SSD 6010 – One Residential Building (Student Accommodation) within Darling Drive

Submission by:

Jennifer Foy

31 July 2013

SHADOW DIAGRAMS: PERSPECTIVE, SHOWING THE PEAK, WINTER SOLSTICE

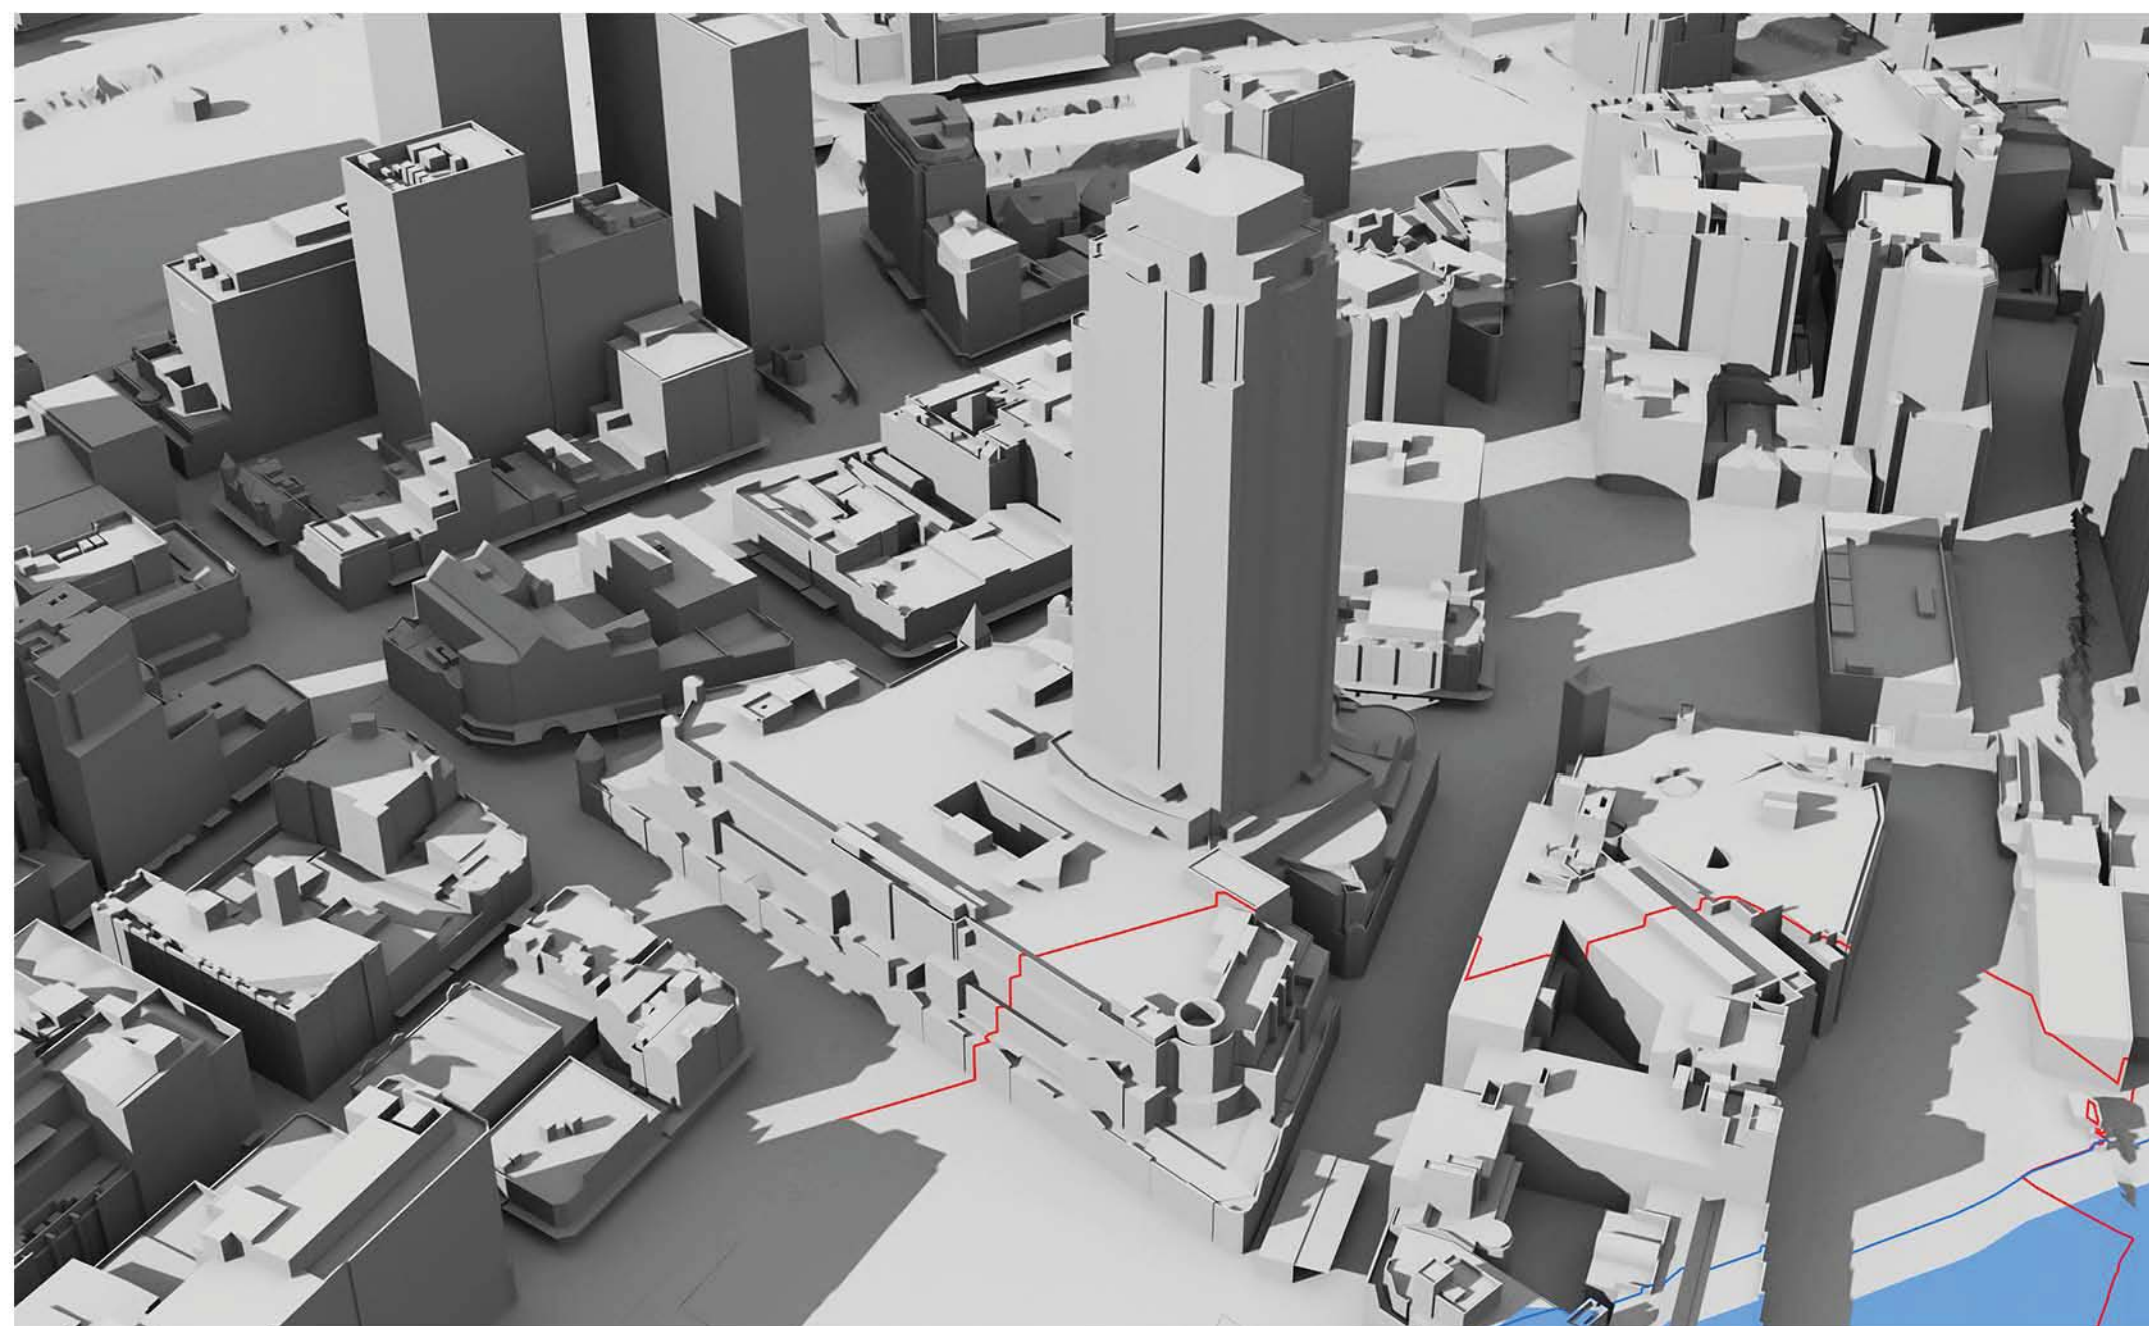
At 9am, 10am and 11am the west façade is totally in shadow due to other parts of The Peak building itself.

At 12pm there is still substantial existing shadowing on the west façade caused by the irregular shape of the west facade.

At 1pm the existing shadowing has been substantially removed, but not totally removed.

It can be concluded that some single aspect apartments on the west façade and some south-west dual aspect corner apartments currently receive less than 2 hours direct sunlight to habitable rooms and 50% of the private open space between 9am and 3pm on 21 June.

By 2pm the existing shadowing has been totally removed, but that is too late to achieve two hours of direct sunlight before 3pm.

At 9am, 10am and 11am the west façade is totally in shadow due to other parts of The Peak building itself.

At 12pm there is still substantial existing shadowing on the west façade caused by the irregular shape of the west facade.

At 1pm the existing shadowing has been substantially, although not entirely, removed. However, overshadowing of lower levels of the west façade by the concept proposal parameter plan shadows for the N,NE and SE plots has already started.

By 2pm the existing shadowing has been totally removed. However, overshadowing of the west façade by the SSDA4 and SSDA5 buildings has appeared and risen further up the west façade than the concept proposal parameter plan shadows for the N,NE and SE plots, which is still present.

At 3pm, the proponent states correctly that 45-45% of the western façade is overshadowed by the SSDA4 and SSDA5 buildings.

It can be concluded that, as a result of combination of the proposed development with existing shadowing of the west façade, some single aspect apartments on the west façade and the south-west dual aspect corner apartments which currently receive less than 2 hours direct sunlight to habitable rooms and 50% of the private open space between 9am and 3pm on 21 June will suffer additional overshadowing. It is beyond our skills to count the number of such apartments. We note that the proponent has made no attempt to do so.
